Application No: R/89/21/HH
Site Address: 74 The Martlets Rustington BN16 2UE
Description of works: Erection of a timber single storey granny annexe for ancillary use to the main dwelling.

Thank you for your internet representation made on 21st May 2021 which has been recorded as an objection with the comments as follows:

East Elevation

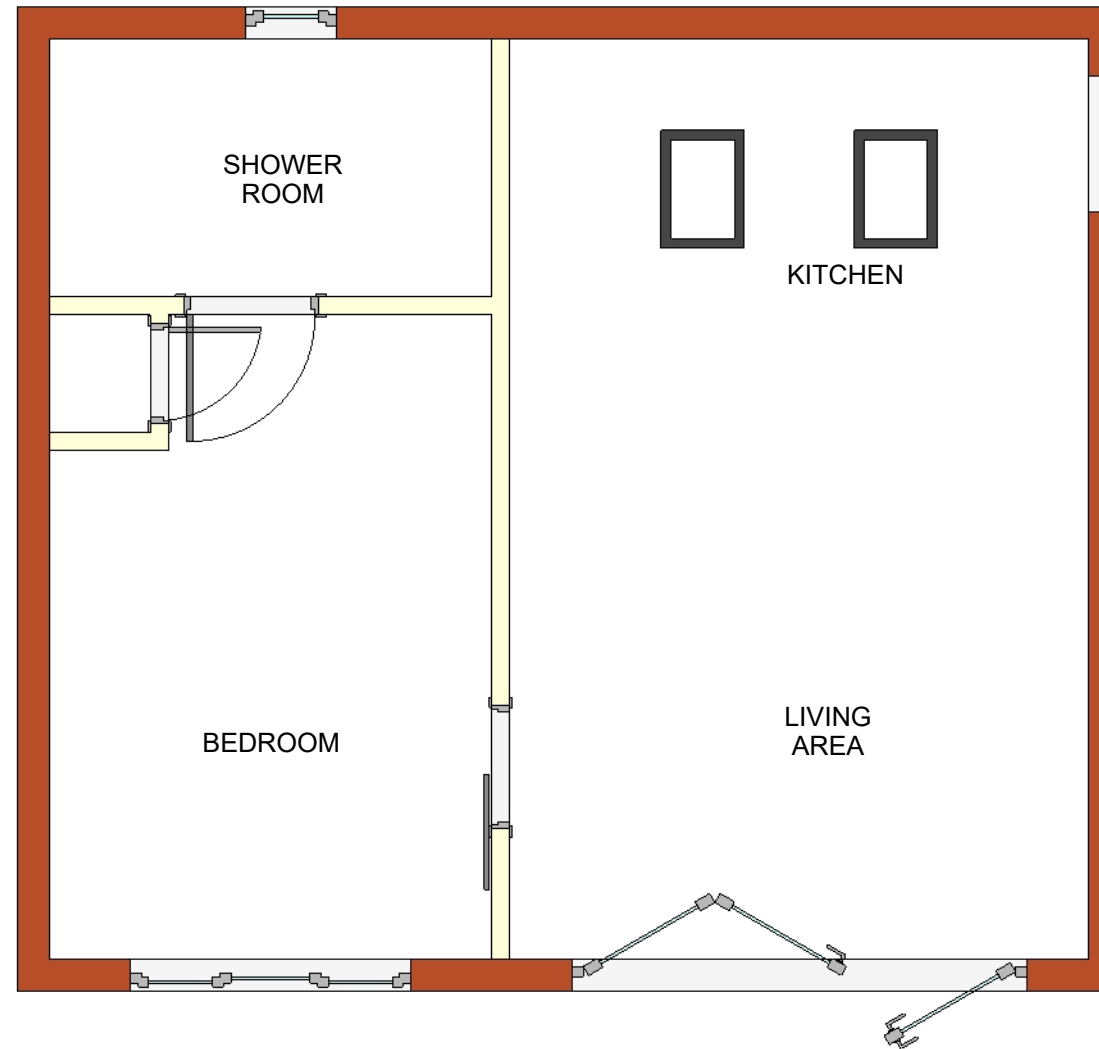
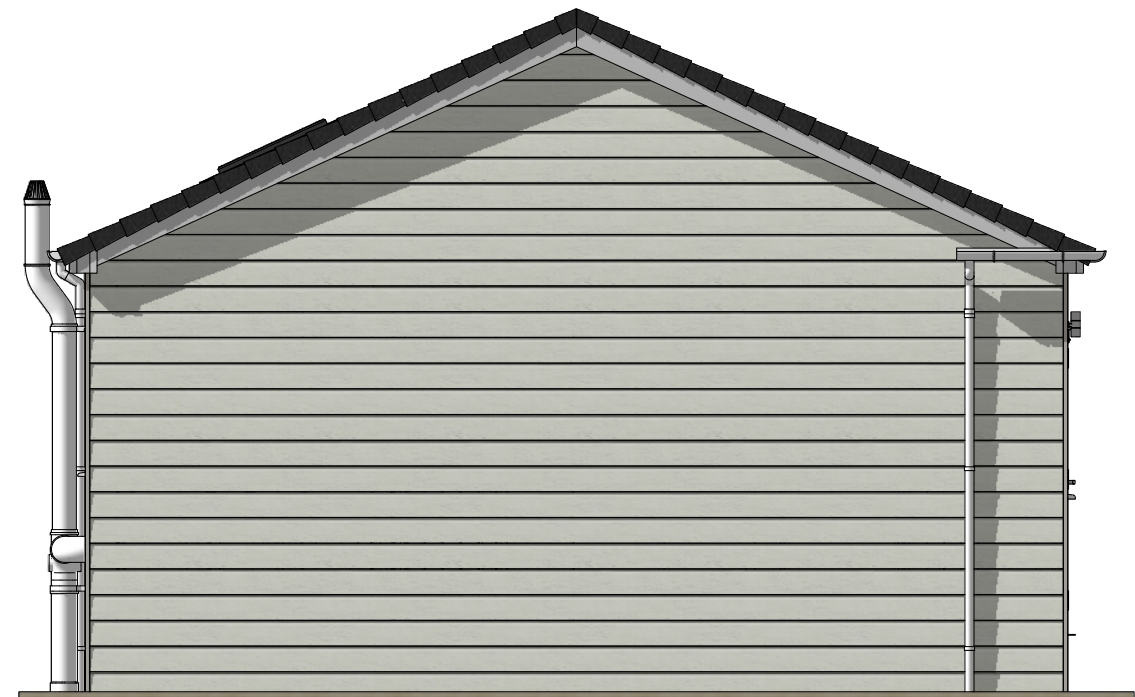
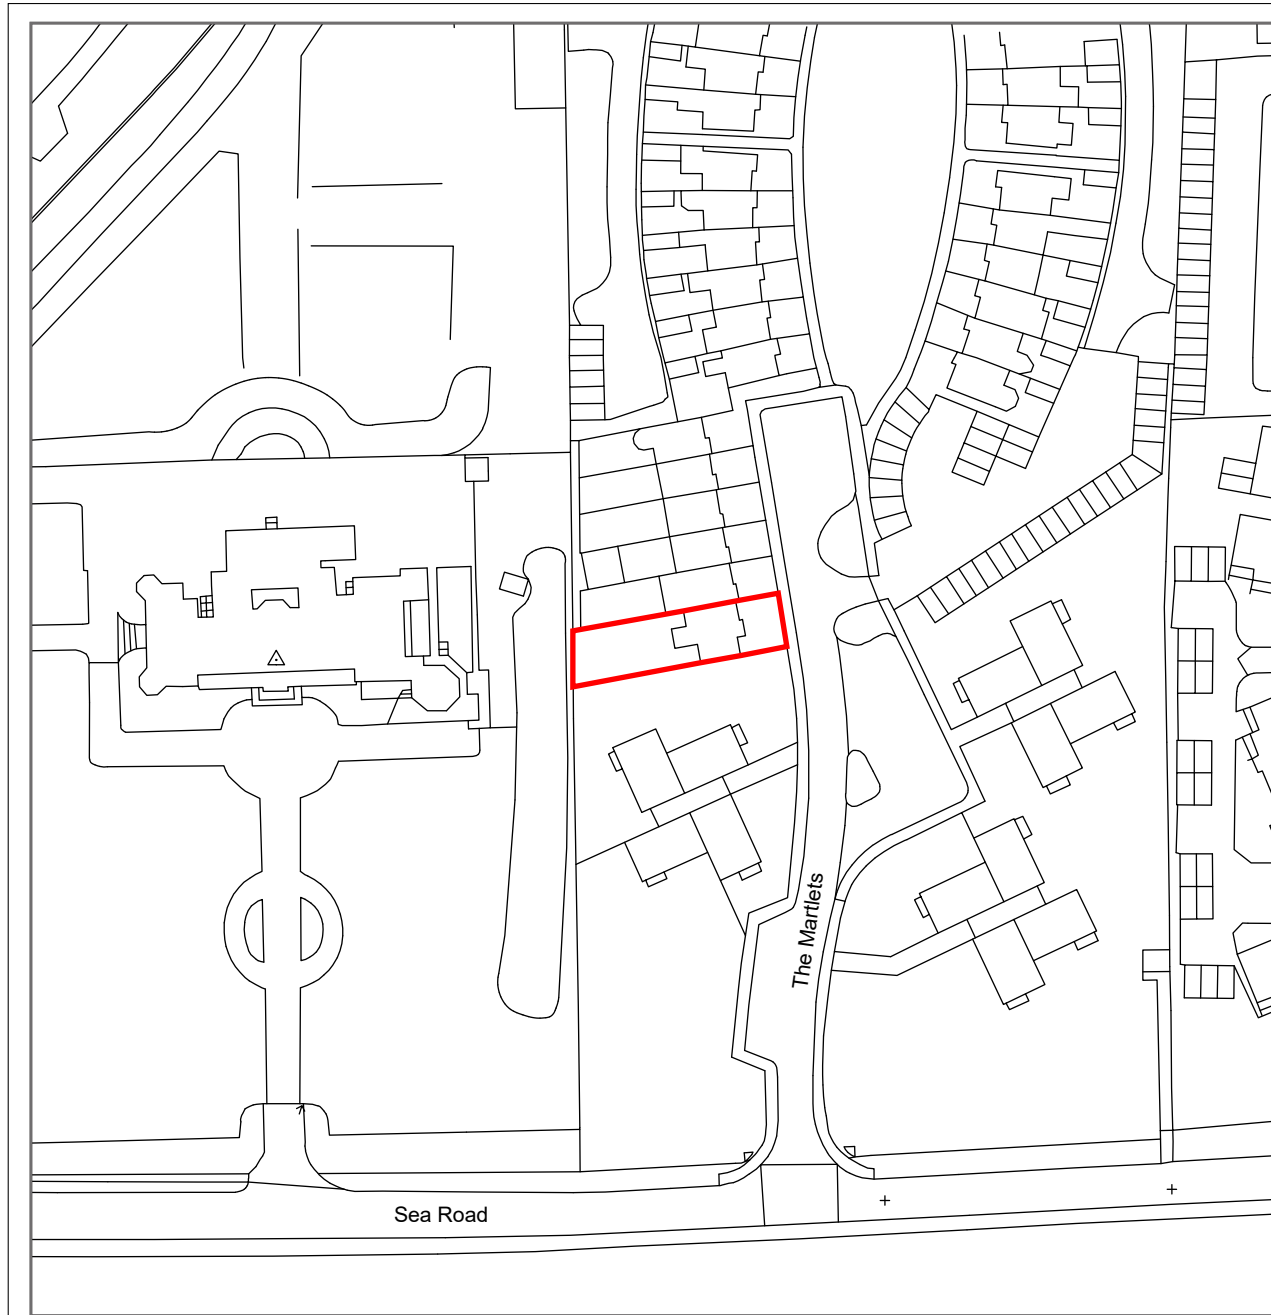
Due to the planned roofing style of this building, it would end up being greater than 2.5m high and would cause a drastic light reduction to the neighbouring gardens and be a blot on the landscape as well as disrupting the neighbours view of the sea.
